National Infrastructure Planning  
Temple Quay House  
2 The Square  
Bristol, BS1 6PN

Our Ref: EN010127

### **Application by Mallard Pass Solar Farm Limited for an Order Granting Development Consent for the Mallard Pass Solar Project**

#### **Advice following issue of decision to accept the application for examination**

No dimensions are to be scaled from this drawing.  
 All dimensions are to be checked on site.  
 Area measurements for indicative purposes only.

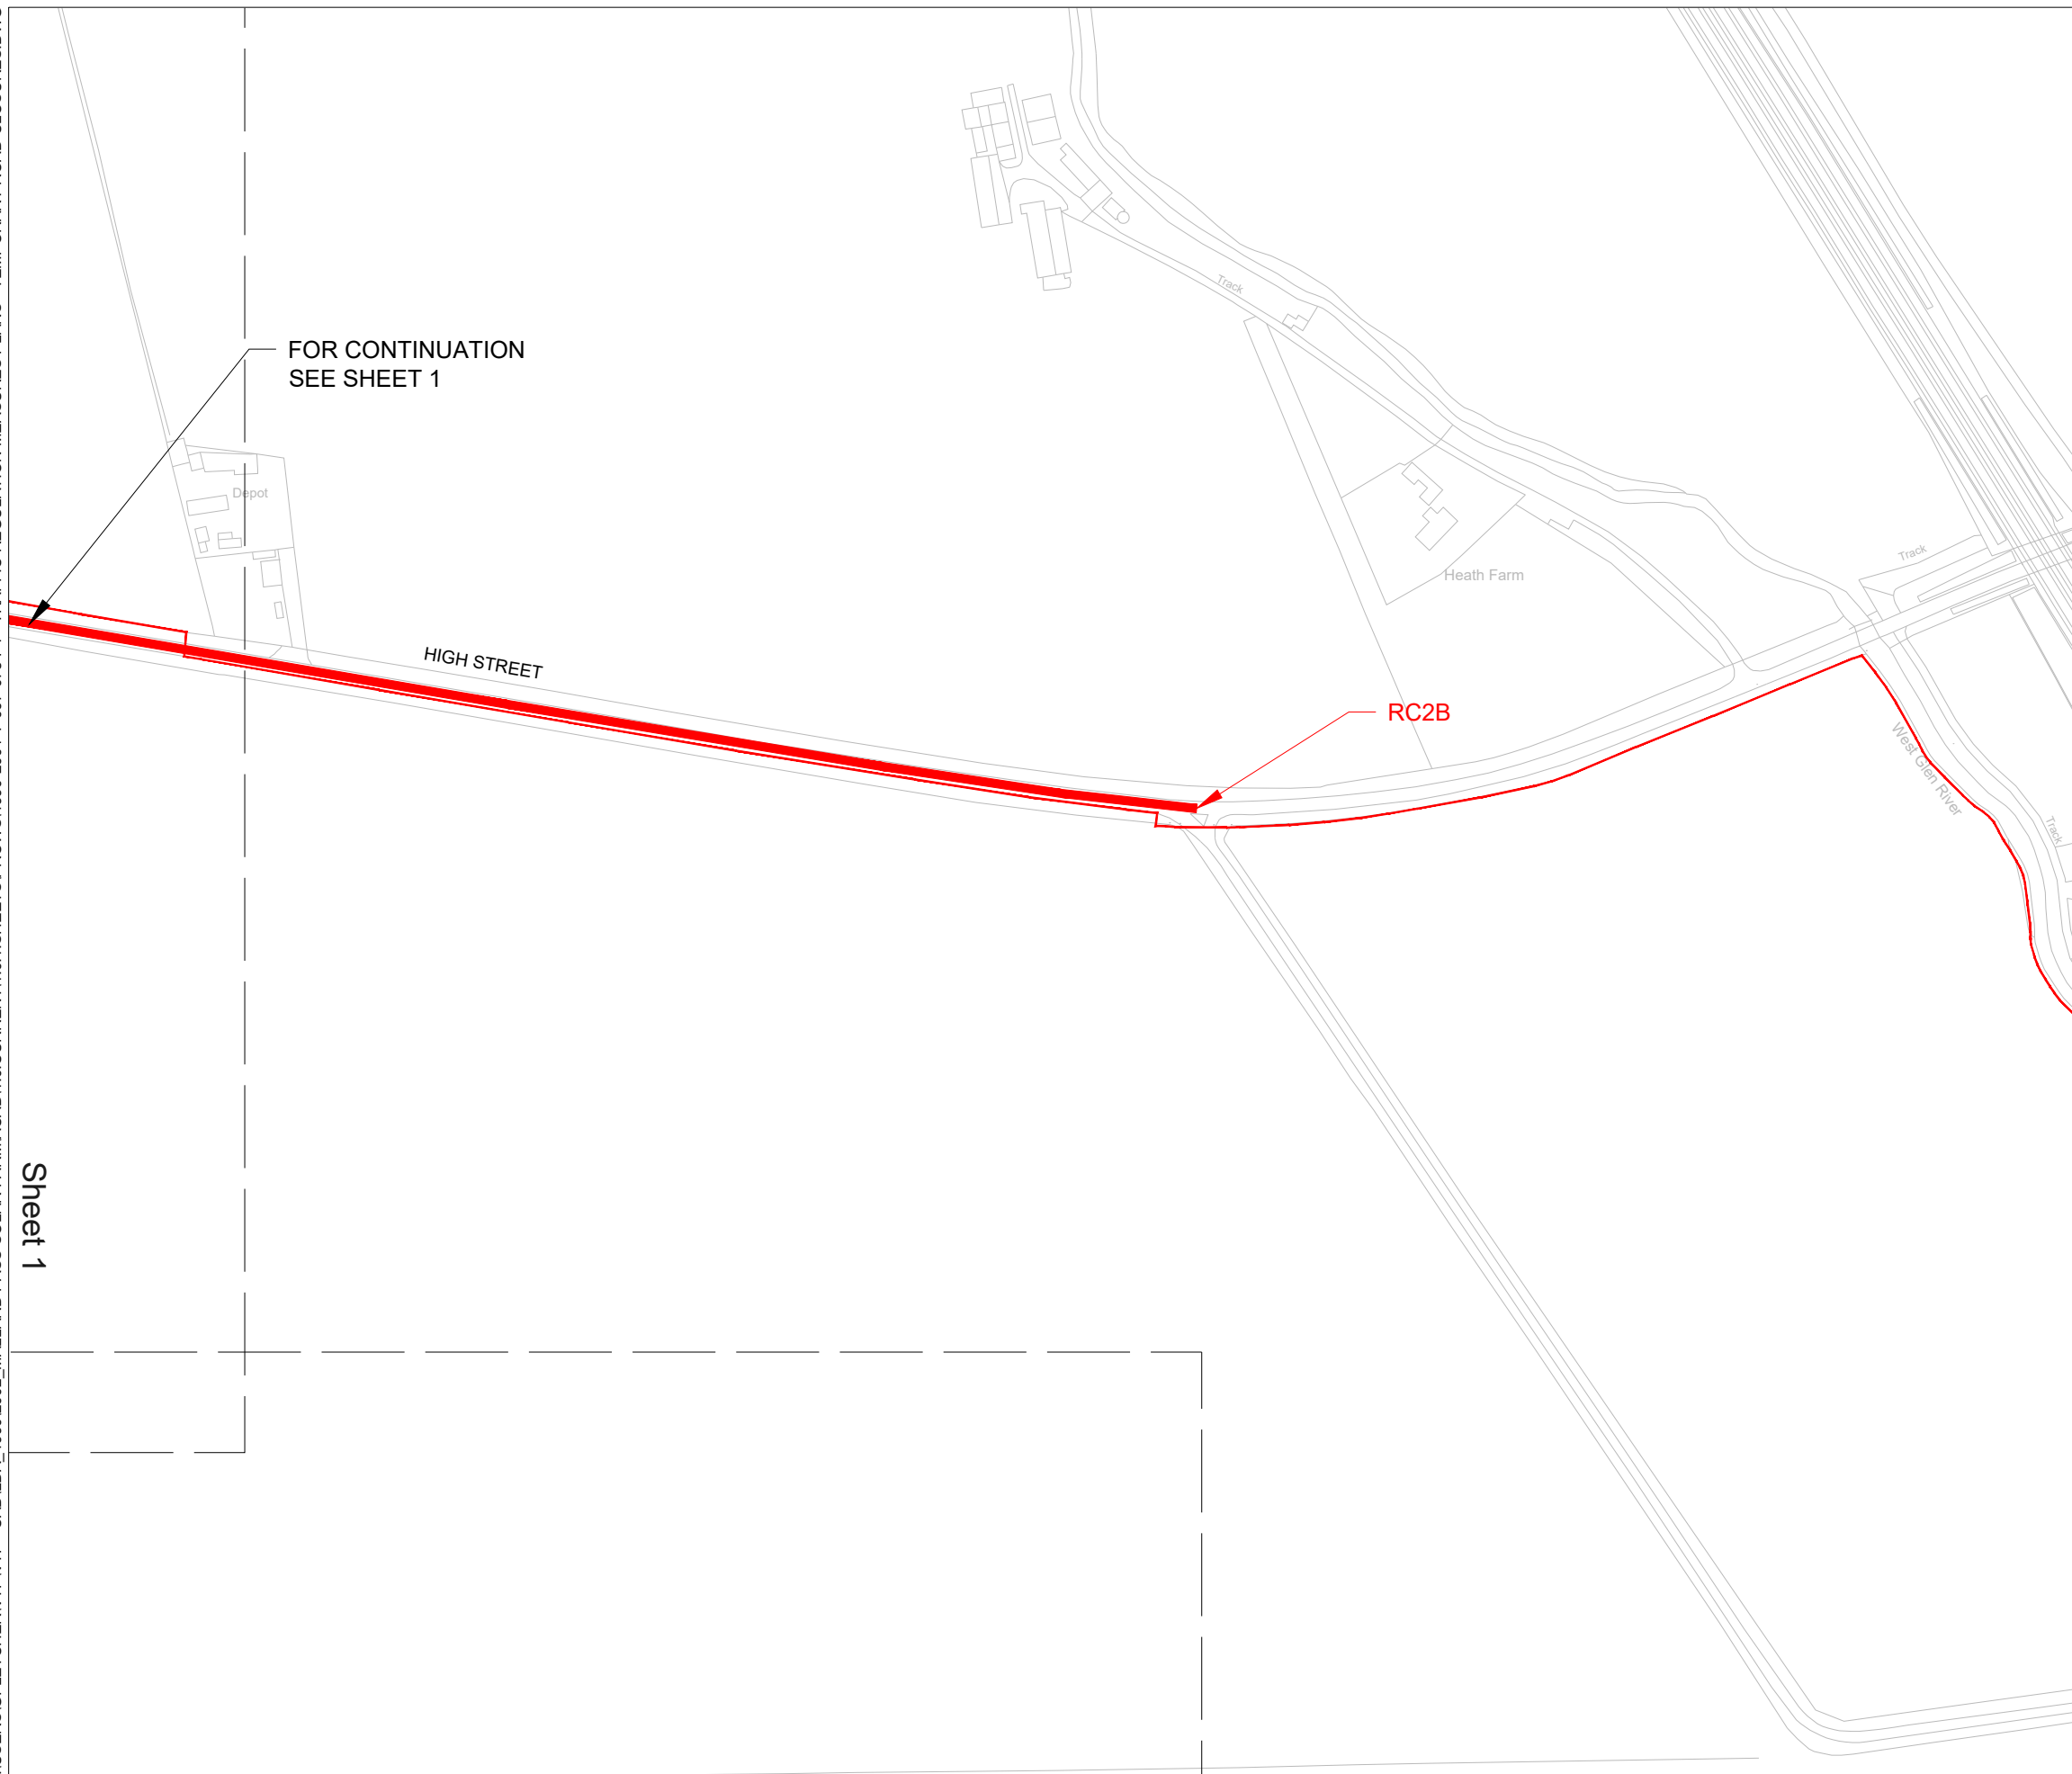
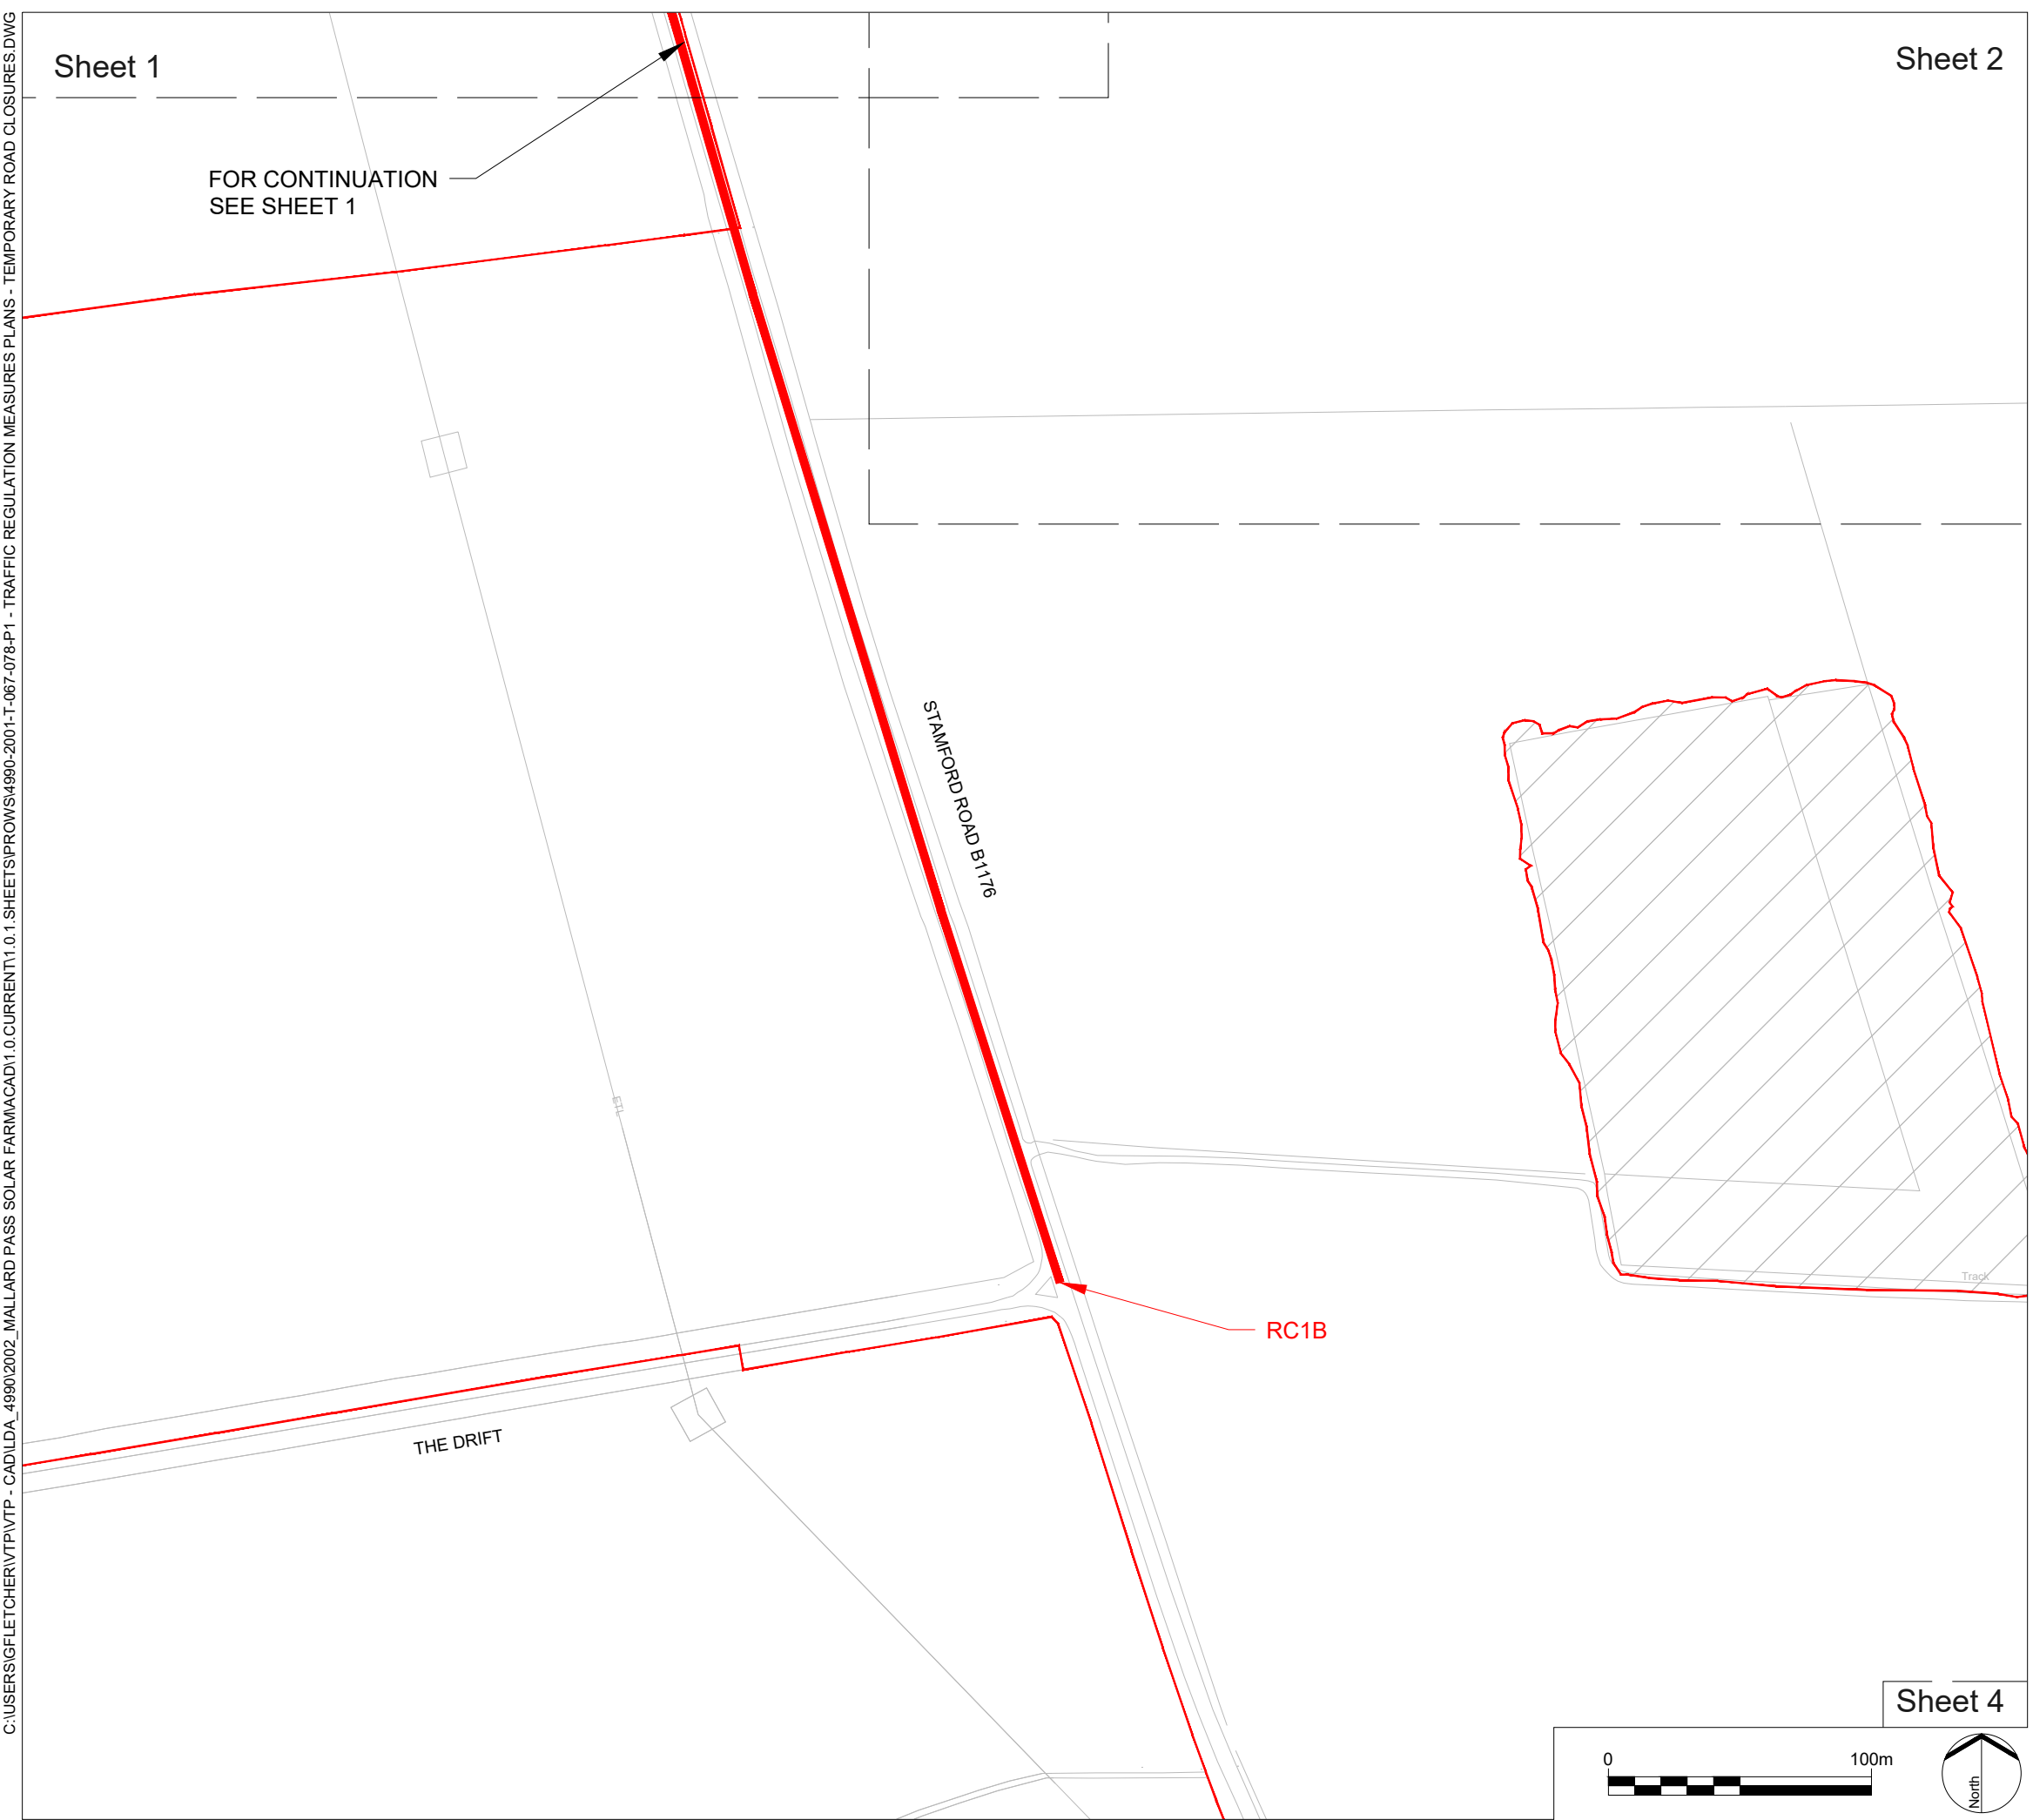
For clarity and to help understanding, existing public footpaths (public rights of way) should be marked and the plans more clearly notated to reflect the proposals, including differentiating works to footpaths and roads.
